Re: Response to Planning Application – LU/328/14/PL
Unit 10 Martello Enterprise Centre, Courtwick Lane,
Littlehampton, West Sussex, BN17 7PA

May I first take the opportunity to thank you for bringing the apparent issues & incorrect items within the above named planning application for the Extension of Unit 10 to my attention.

Proposed Extension for RJH Construction
Unit 10 Martello Business Centre, Courtwick Lane, Littlehampton
- AS EXISTING + Proposed Roof Plan

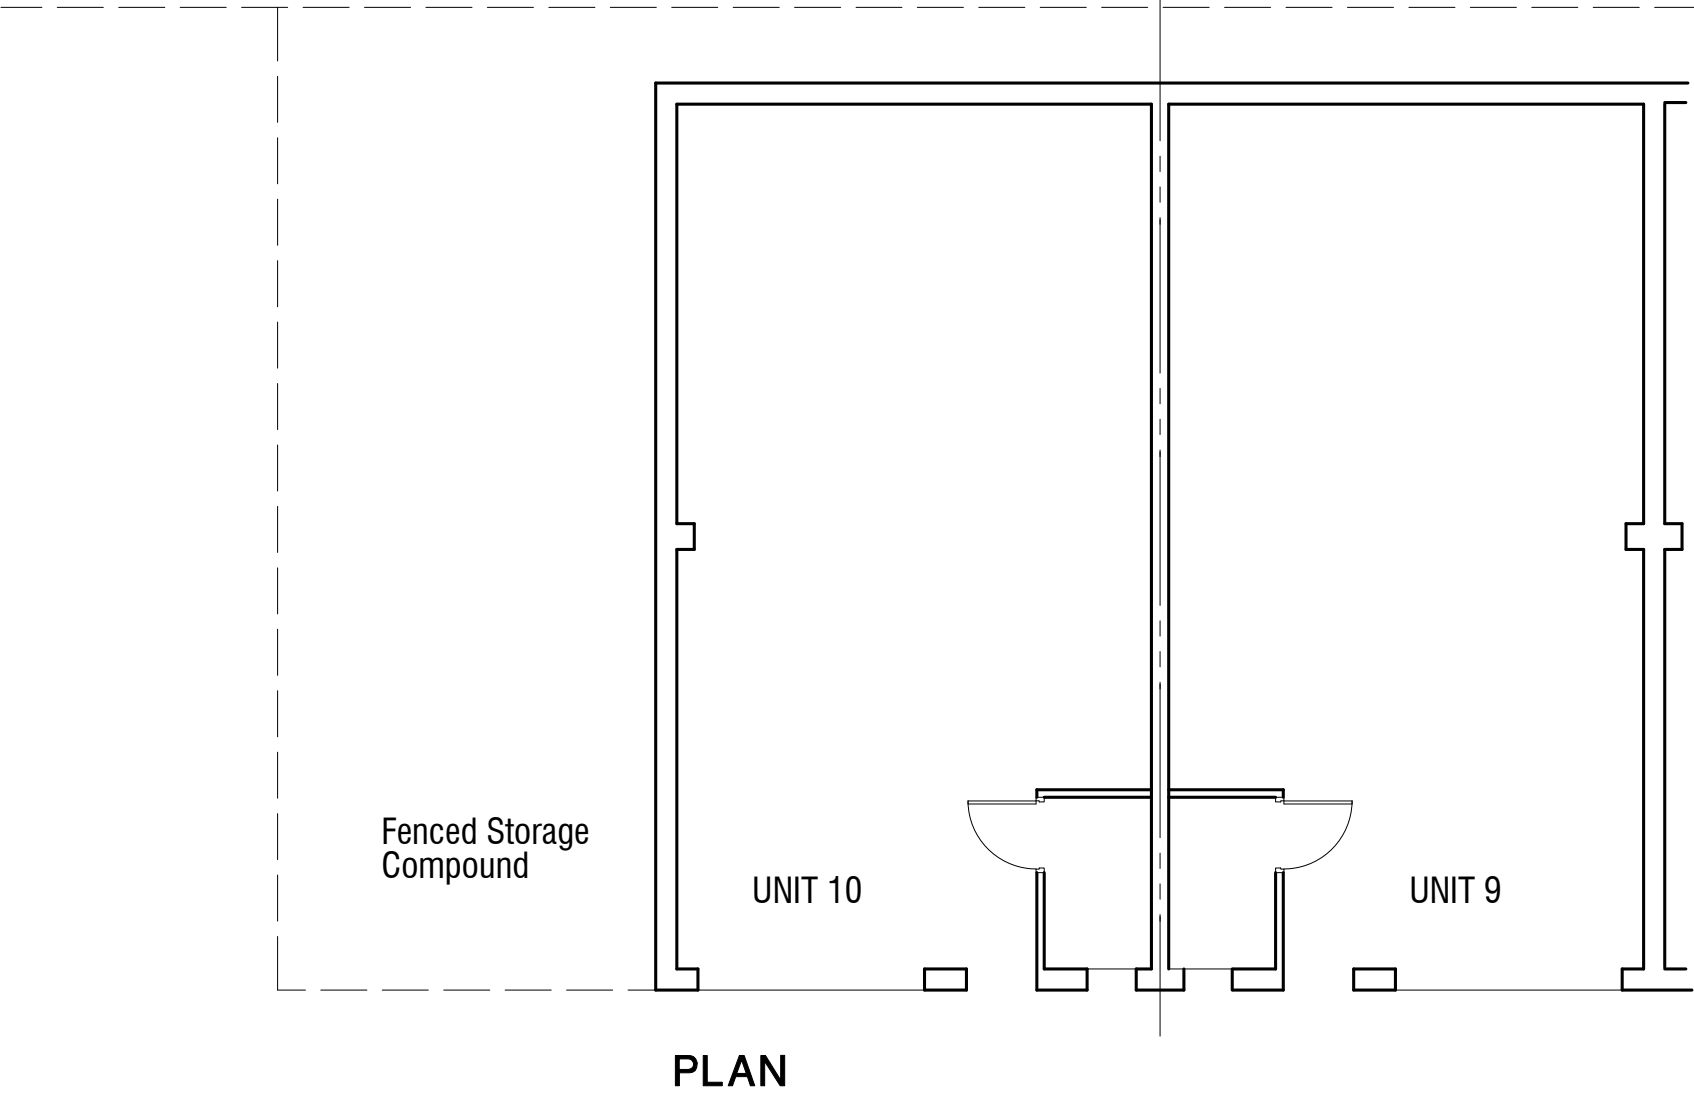
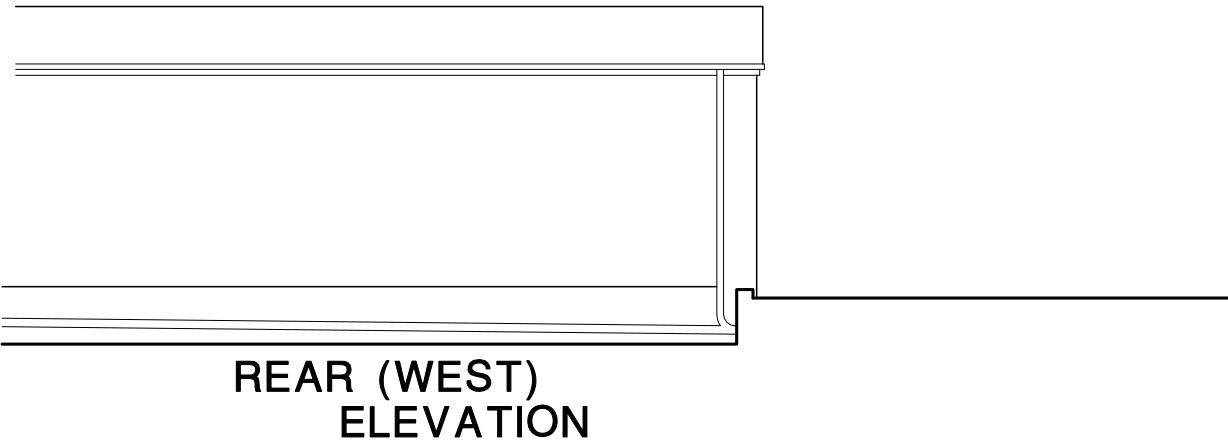
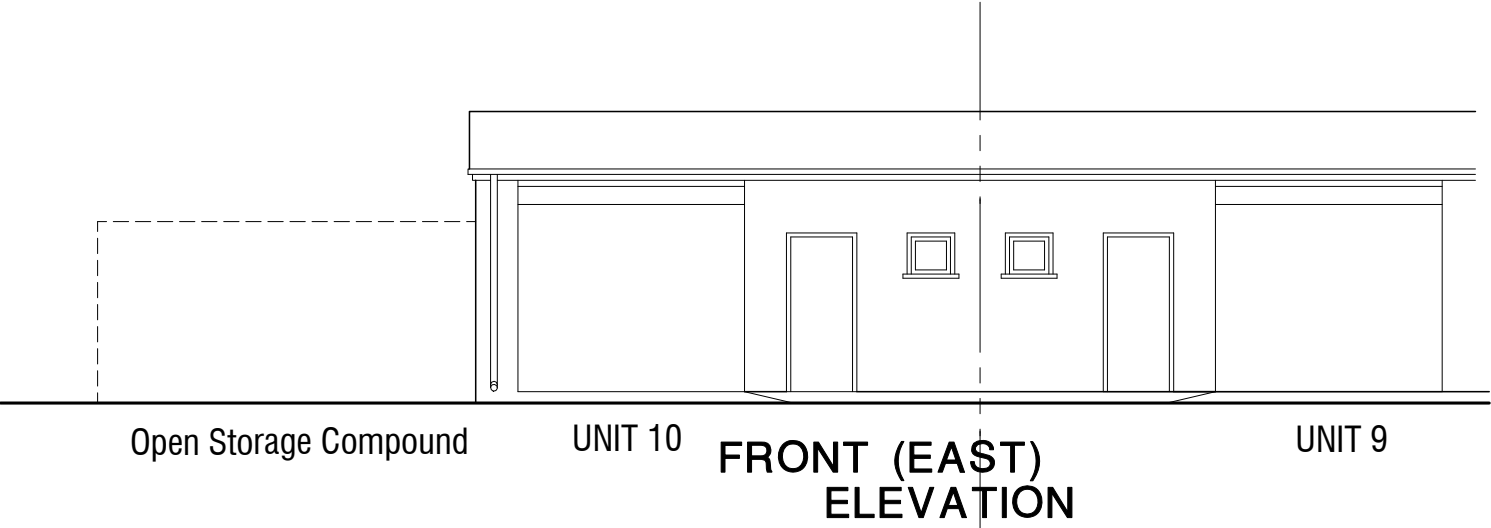
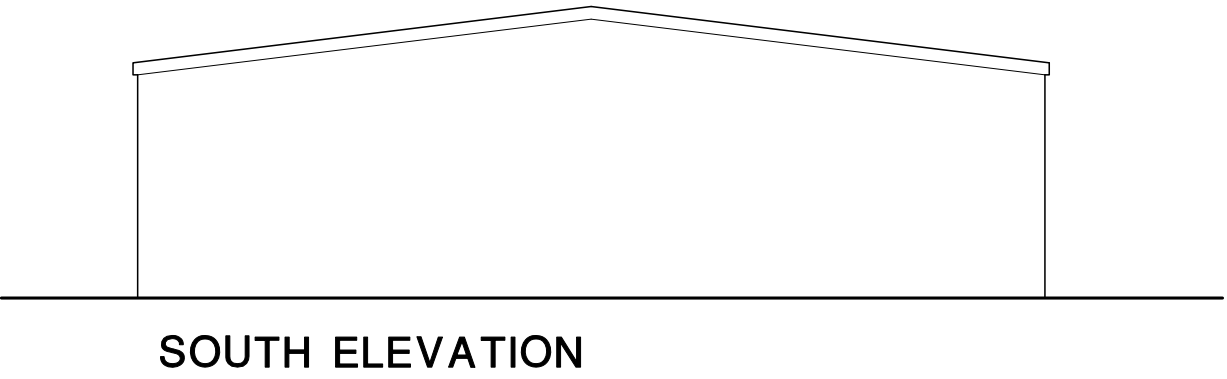
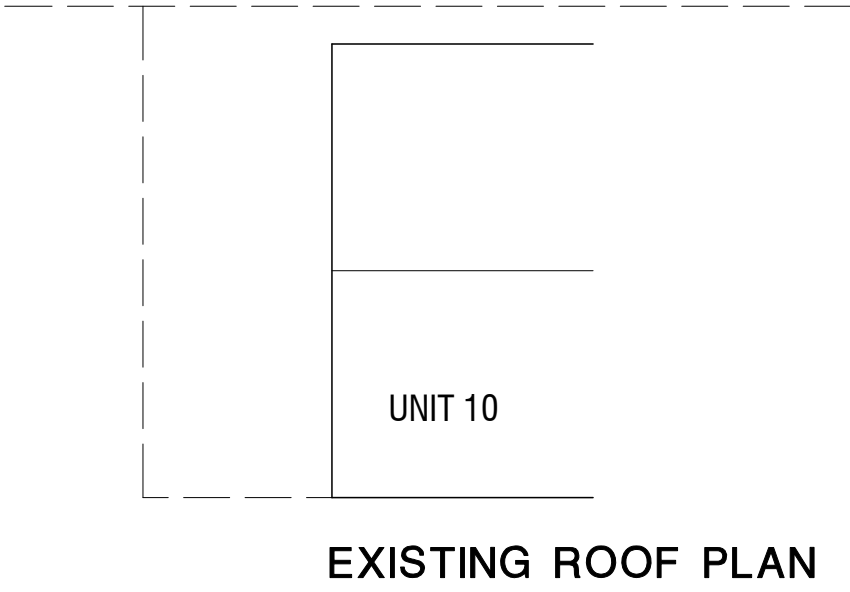
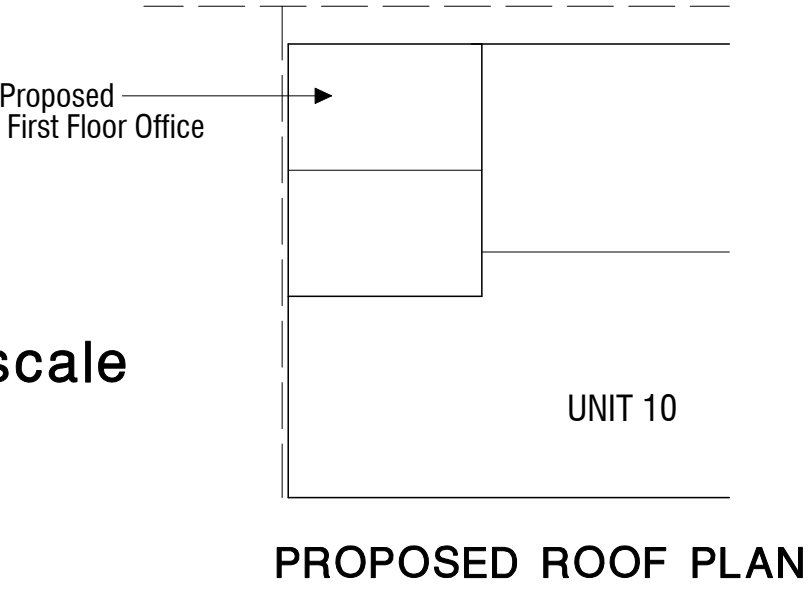
Your statement: *'The placement of Parking Spaces is not under the control of the individual units. Your application shows a change of location of a parking space.'*

Your statement: *'Your notation states an additional parking space'*

Your statement: *'Your application shows your new building using existing surface water drains within the common parts of the MECMCL.'*

Your statement: *'Your application shows an entry Ramp constructed on the MECMCL Common Parts.'*

Your statement: *'Your application shows a boundary outside of the building boundary which implies that you have control within that boundary.'*

Your statement: *'Your application shows a new door opening onto the MECMCL Common Parts.'*

Your statement: *'Your application shows the placement of rubbish bins on the MECMCL Common Parts.'*

'The planning application as described in planning application LU/328/14/PL is considered out of character with the other units within the Martello Enterprise Centre. That is to say that the other adjacent units are single storey and the original concept as planned by the developers of the industrial estate was a simple single storey unit extension.'

'It is also worthy of note that your planning application if enacted would severely limit vehicle access to Unit 11 and prevent the free and unhindered access to this unit.'

While I completely accept all ownership and control of common areas by the Management Company I must state that this slight movement of the 2nd front facing car parking space is an error and will be amended on the plans.

Our plans show all 3 parking spaces as originally displayed by PJR Building Surveyors Project Managers drawing titled 'Car Park Layout' (Drawing Number: B15/01/12 C) I have taken the liberty of attaching the aforementioned drawing to this letter.

I quite agree our drawing shows use of existing surface water drainage which was previously permitted on application LU/194/07 & Scheme LU/280/01 (as originally agreed with the Environment Agency)

Again, I wish to refer back to previously approved scheme LU/194/07 You will note all ground floor front (East) Elevation designs on LU/328/14/PL are in fact direct copies of the front (East) Elevations shown on LU/194/07 – again I have included & highlighted to indicate the proposed ramped access.

Again, referring to approved scheme LU/194/07. All block plans and relating plans indicating site boundary are carbon copies of aforementioned approved scheme. We have strictly kept within the boundaries permitted for Unit 10 and would never look to exceed these limitations.

An exit/entry door opening is show on our application (LU/328/14/PL) exactly as shown on approved scheme LU/194/07. Which again arises a similar question as previously mentioned in this letter; why is such an objection to a previously approved and agreed item.

One further point directly relating to our application LU/328/14/PL, the design shows a WC in the proposed extension this is to be removed, there will be no need for a WC therefore no new foul drainage as the proposed is purely an extension to Unit 10.
